Begbroke Science Park

Oxford University Development LTD

Reserved Matters Submission Design Statement Design Updates Comparison

04 November 2022

Axonometric view of a typical structural bay showing façade build-up and proposed material finishes.

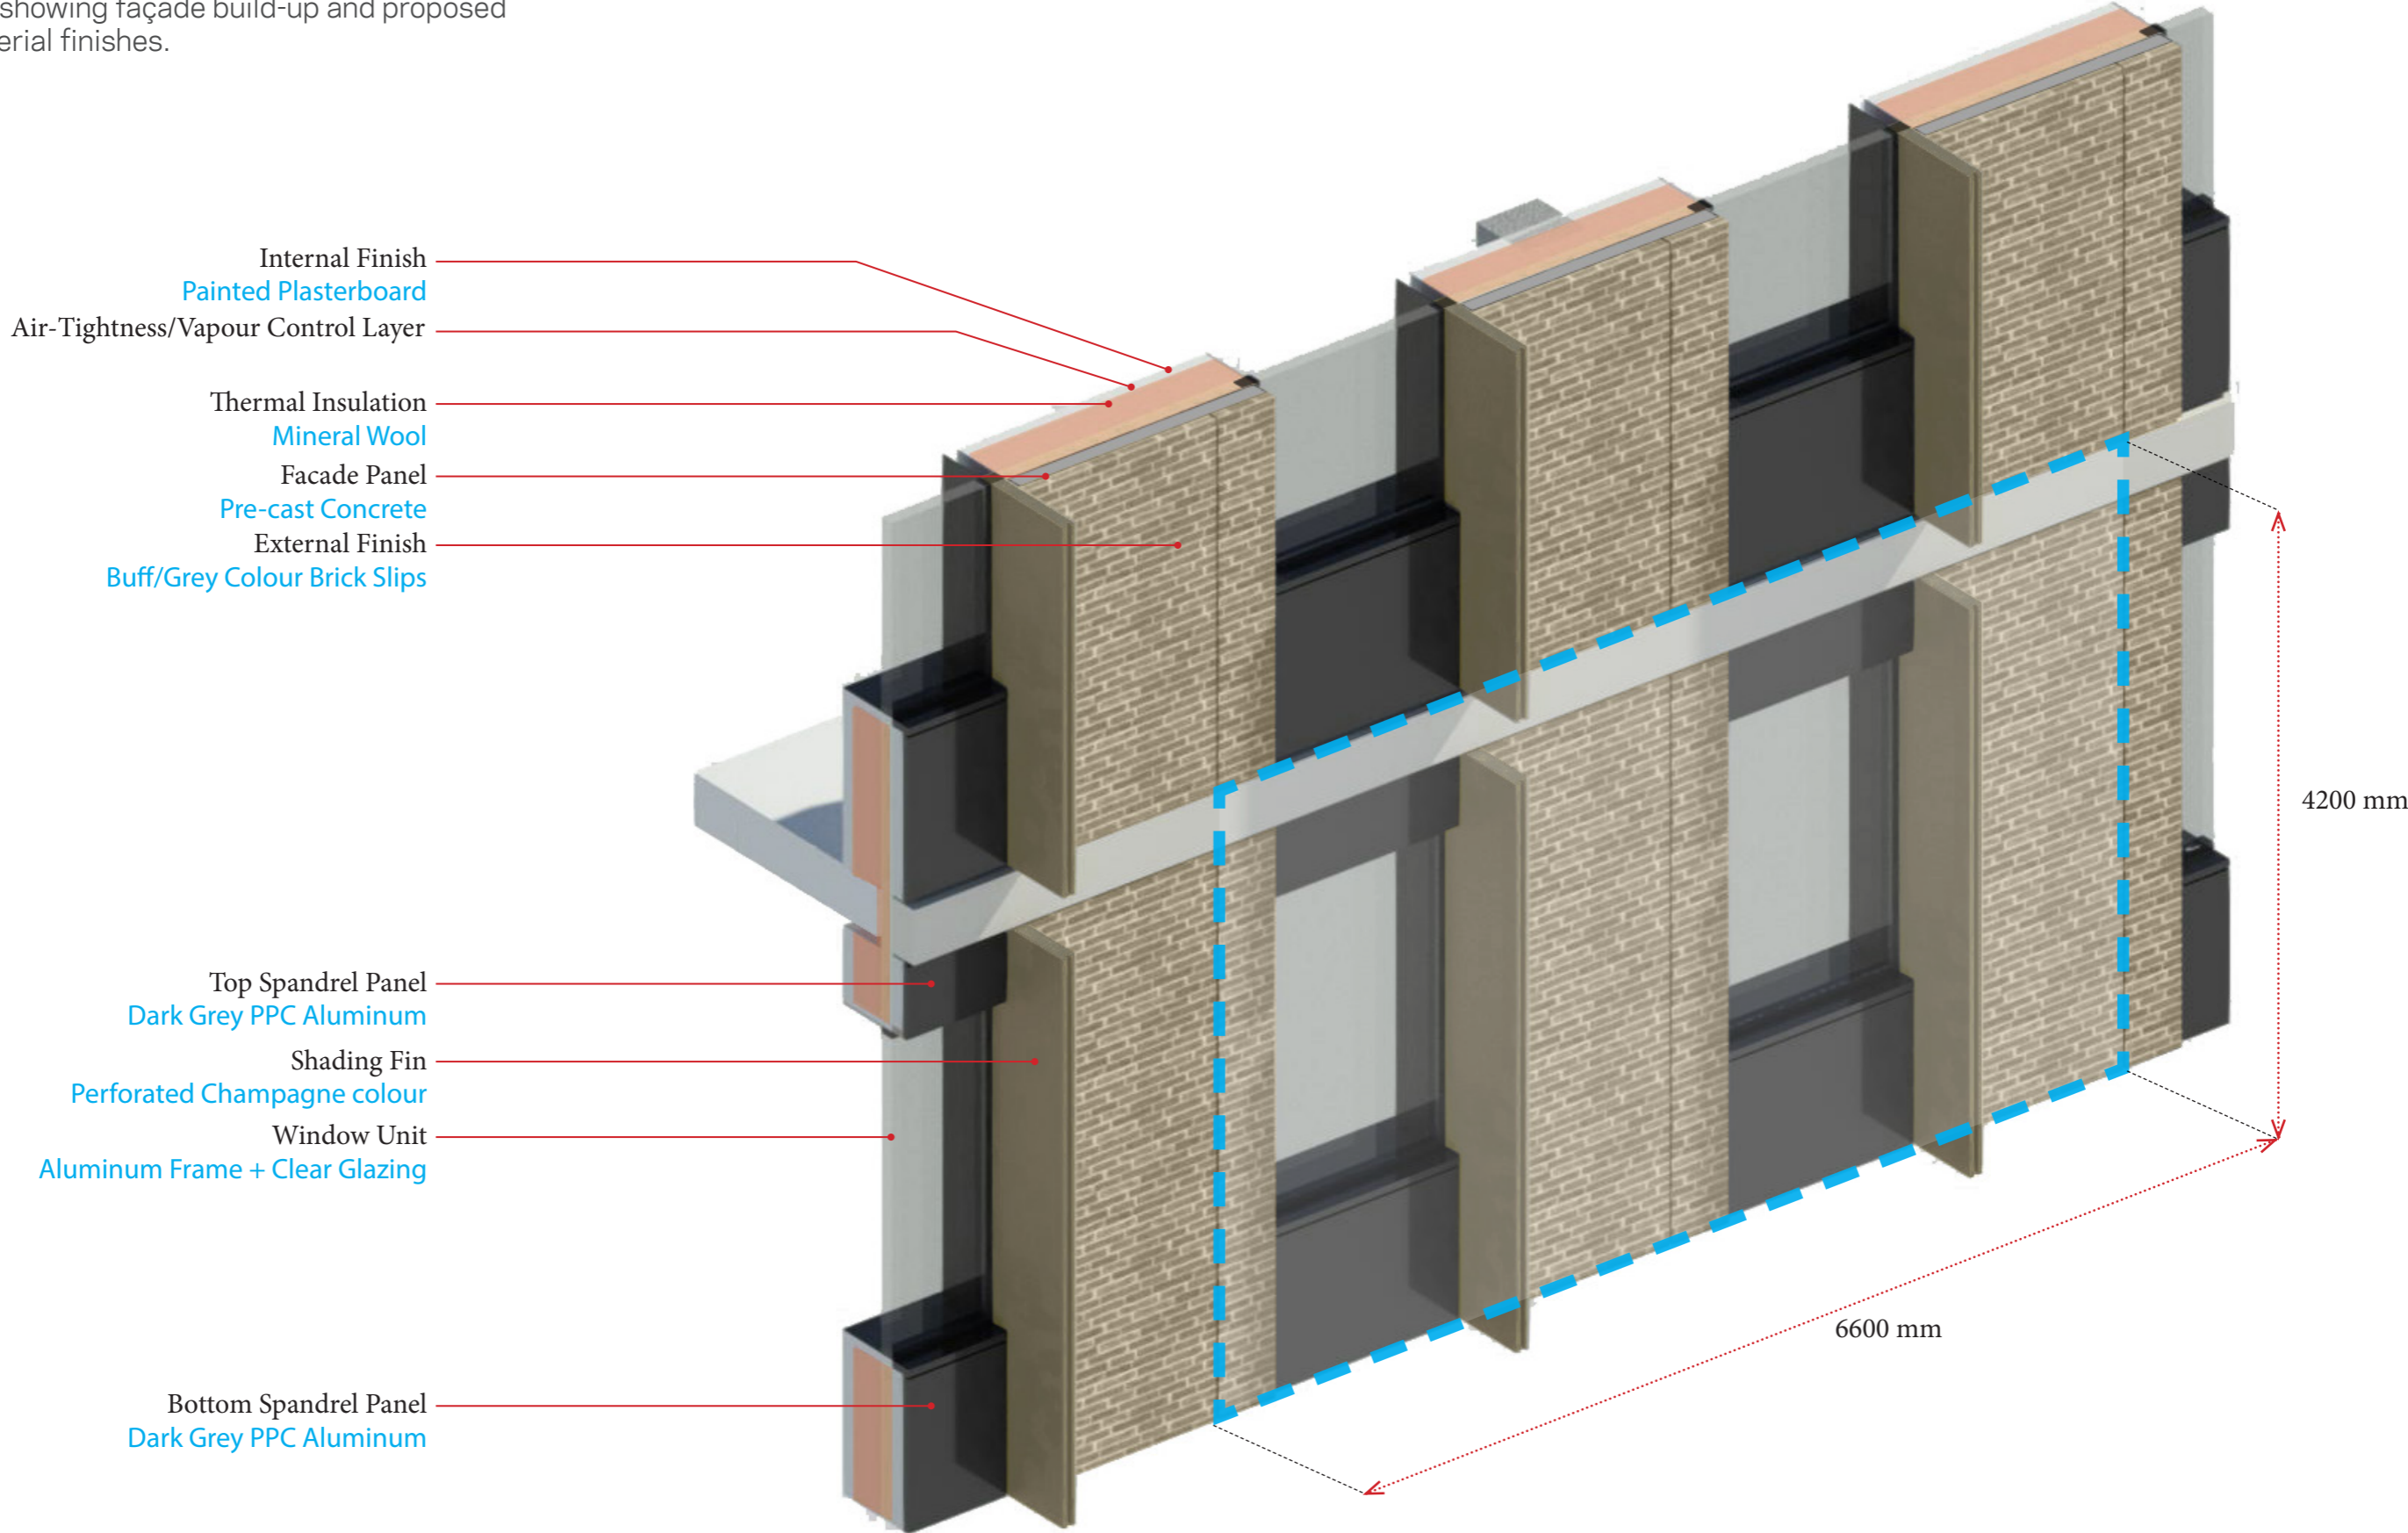
4.0 Proposed Façade Concept Strategy - Updated materials

- Internal Finish
Painted Plasterboard
- Air-Tightness/Vapour Control Layer
- Thermal Insulation
Mineral Wool
- Facade Panel
Pre-cast Concrete
- External Finish
Buff/Grey Colour Brick Slips

- Top Spandrel Panel
Dark Grey PPC Aluminum
- Shading Fin
Perforated Champagne colour
- Window Unit
Aluminum Frame + Clear Glazing

4.4 Proposed Facade Material Palette

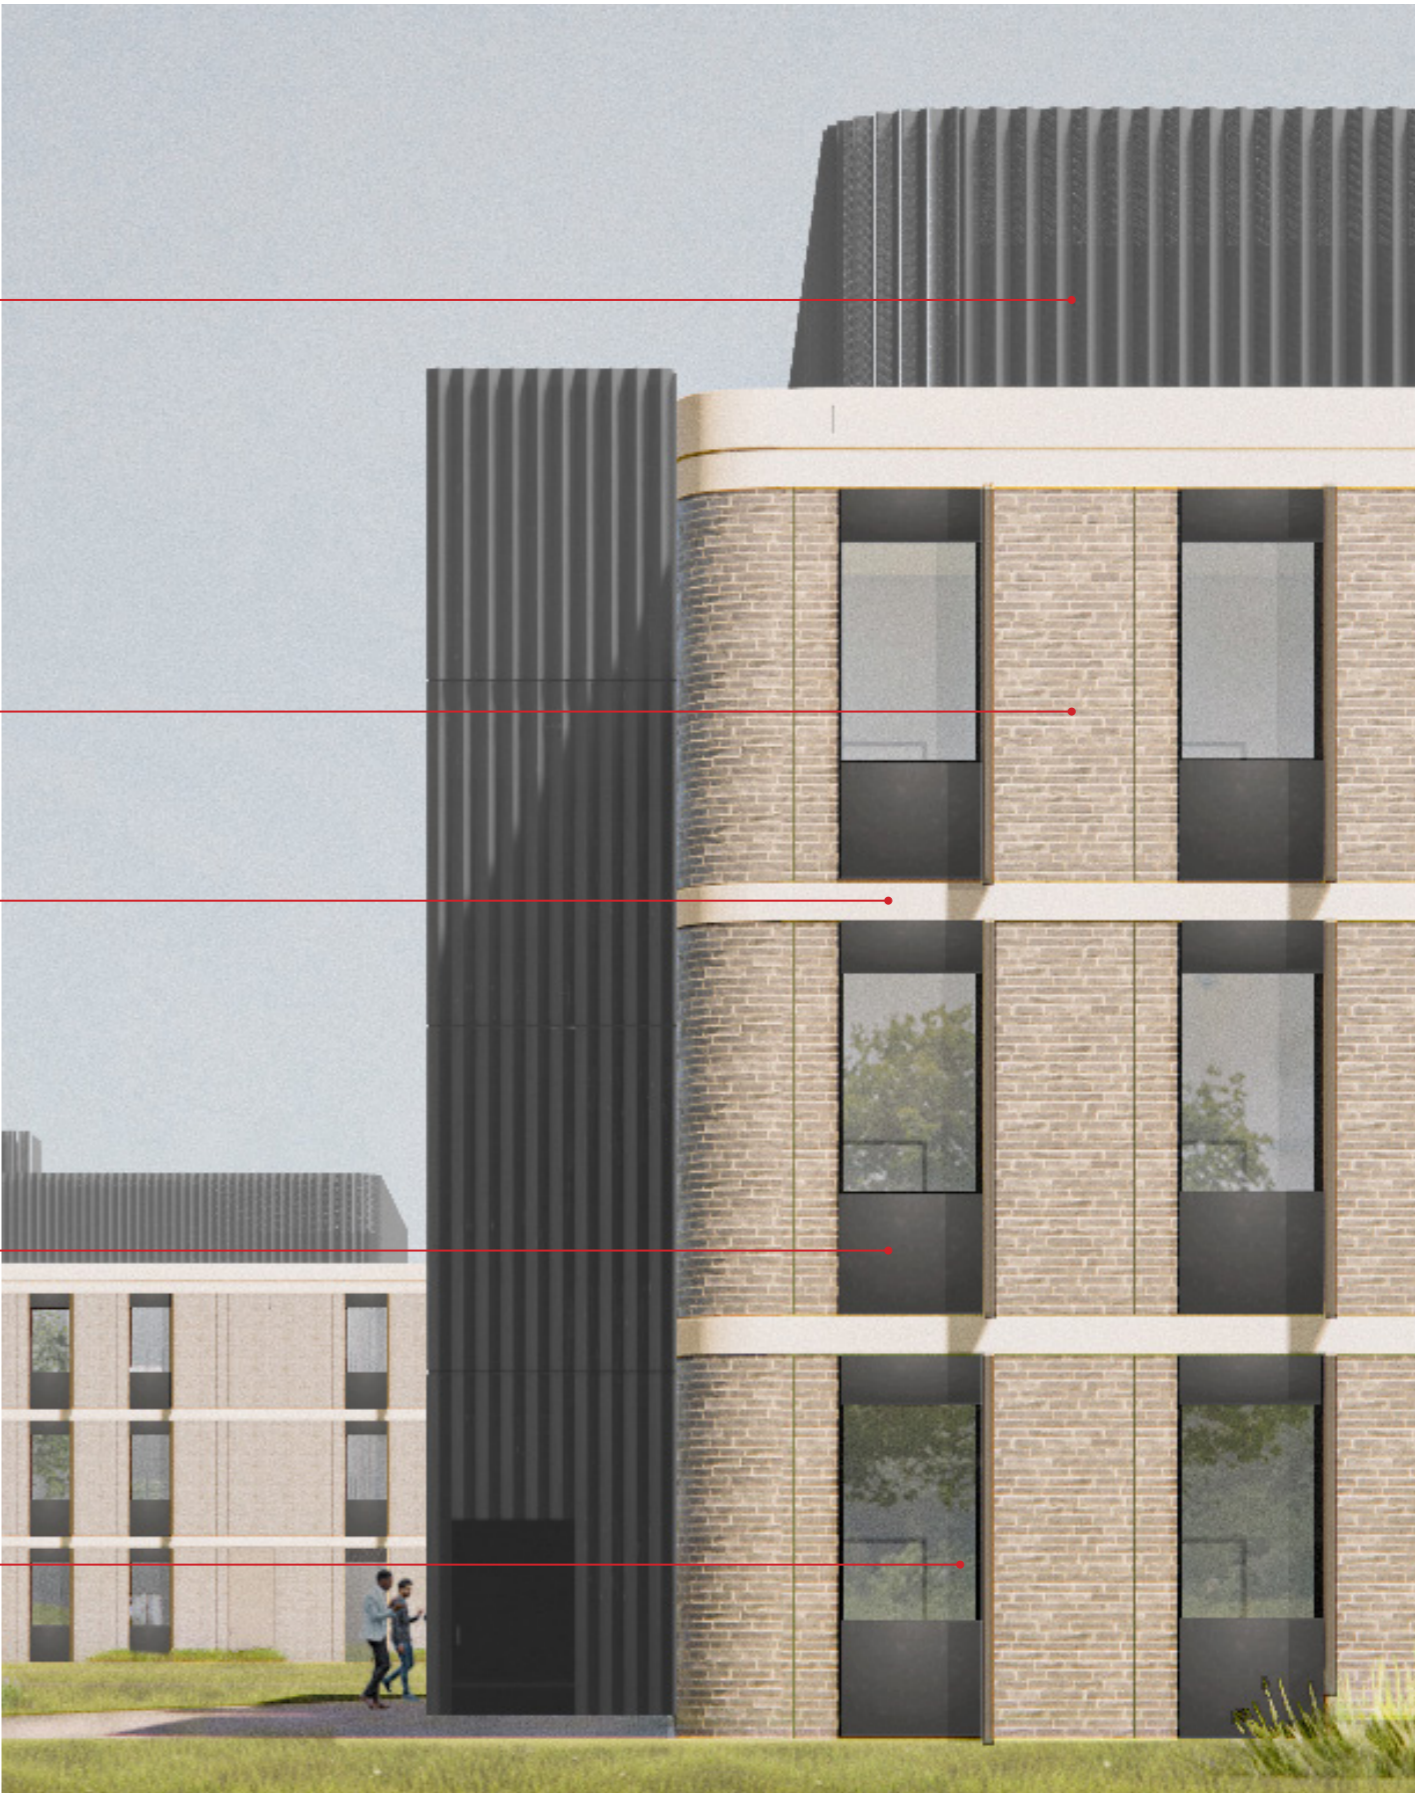
4.4 Updated Facade Material Palette

Bricks:
grey/buff blend

Shading Elements:
Perforated PPC 'champagne' colour

1 PROPOSED EAST ELEVATION - COMMERCIAL BUILDING
1:100

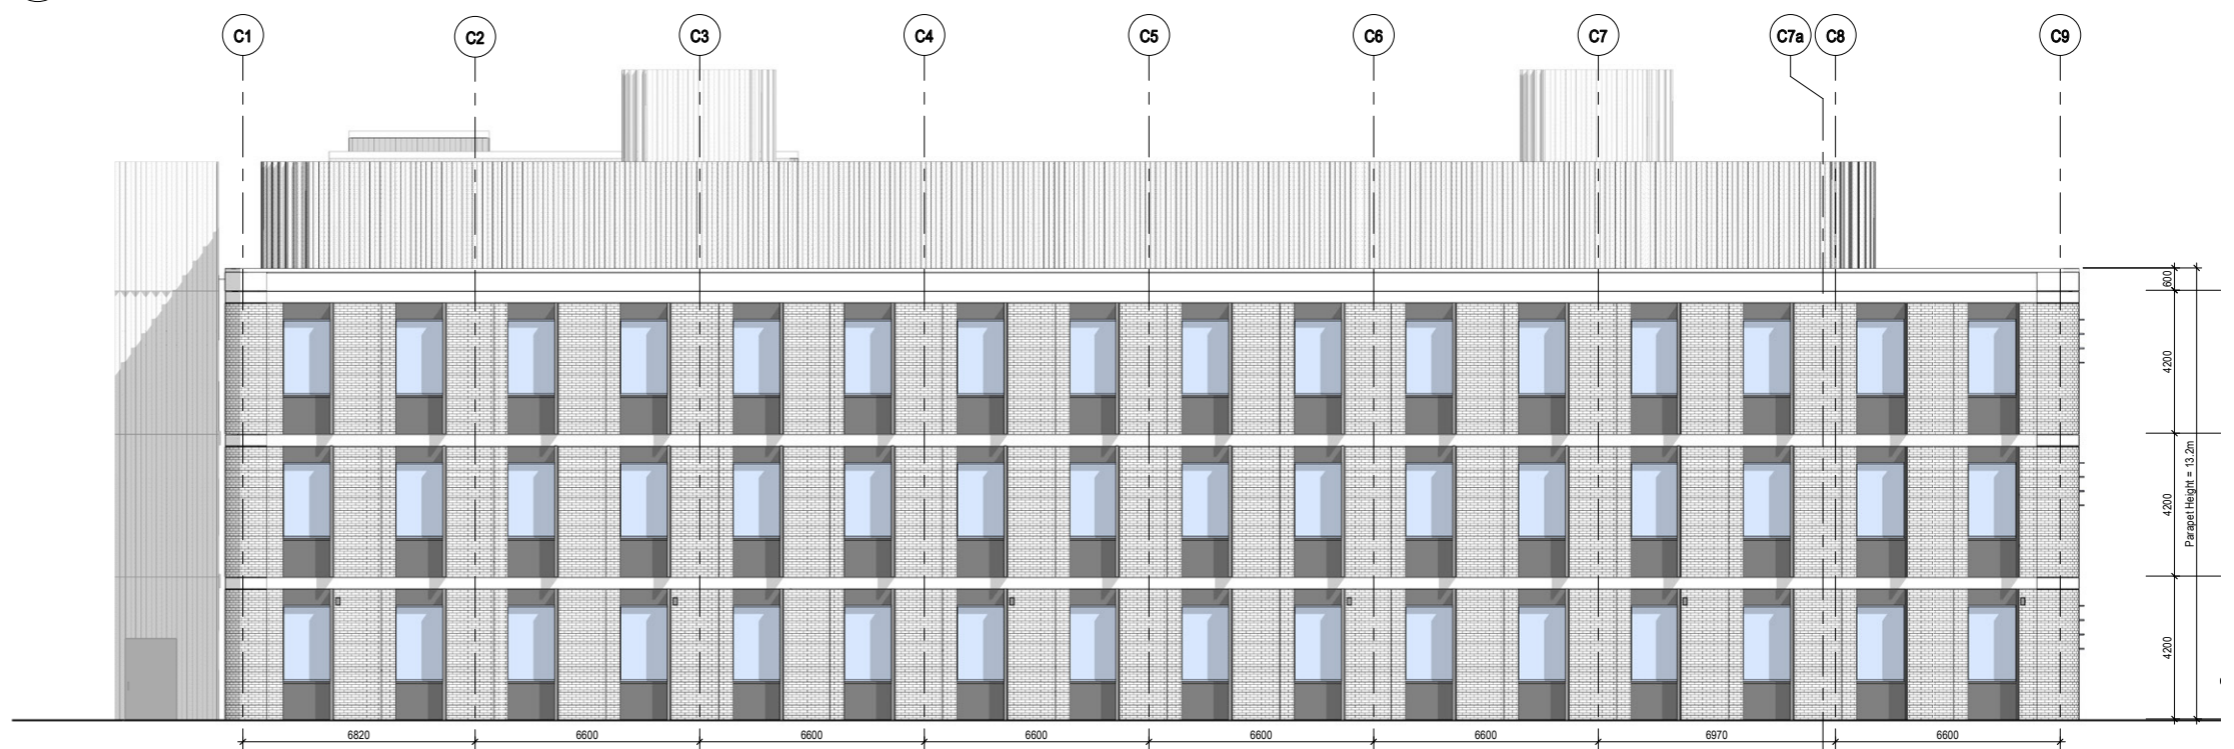
4.0 Proposed Facade Concept Strategy - Updated Materials

4.4 Updated Facade Materials - Commercial Building

1 PROPOSED NORTH ELEVATION - ACADEMIC BUILDING  
1:100

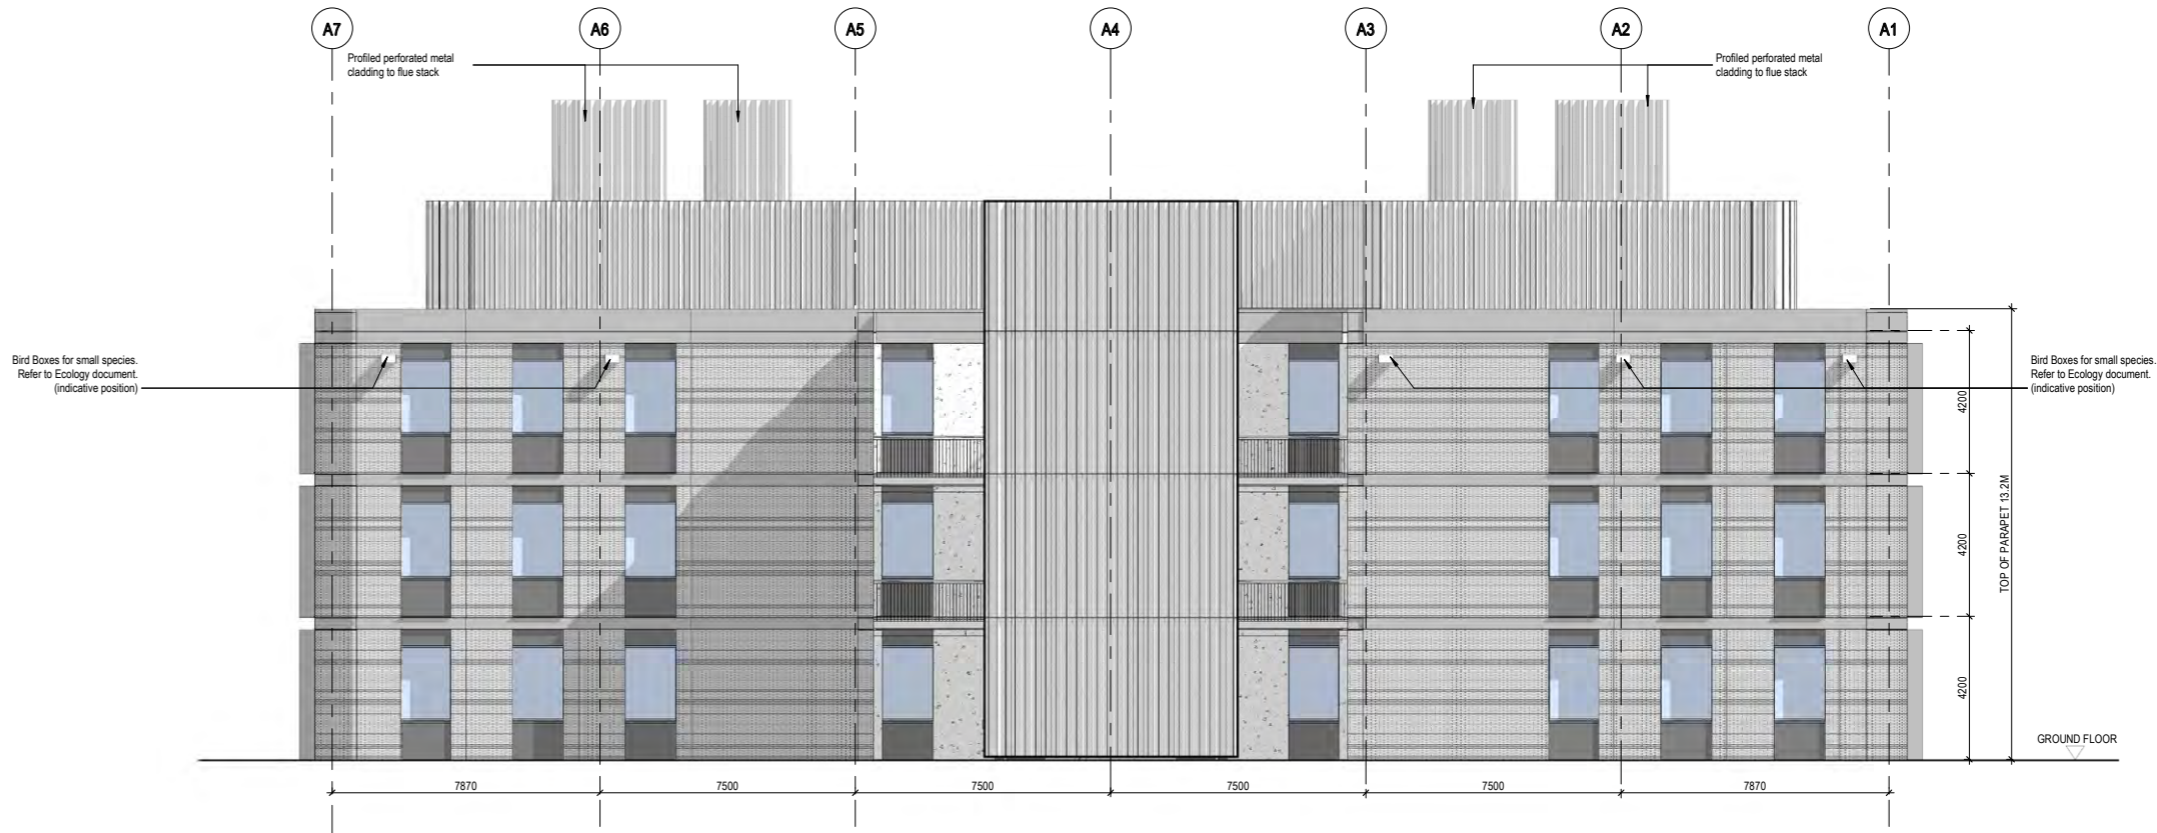
4.0 Proposed Facade Concept Strategy - Updated Materials

4.4 Updated Facade Materials - Academic Building
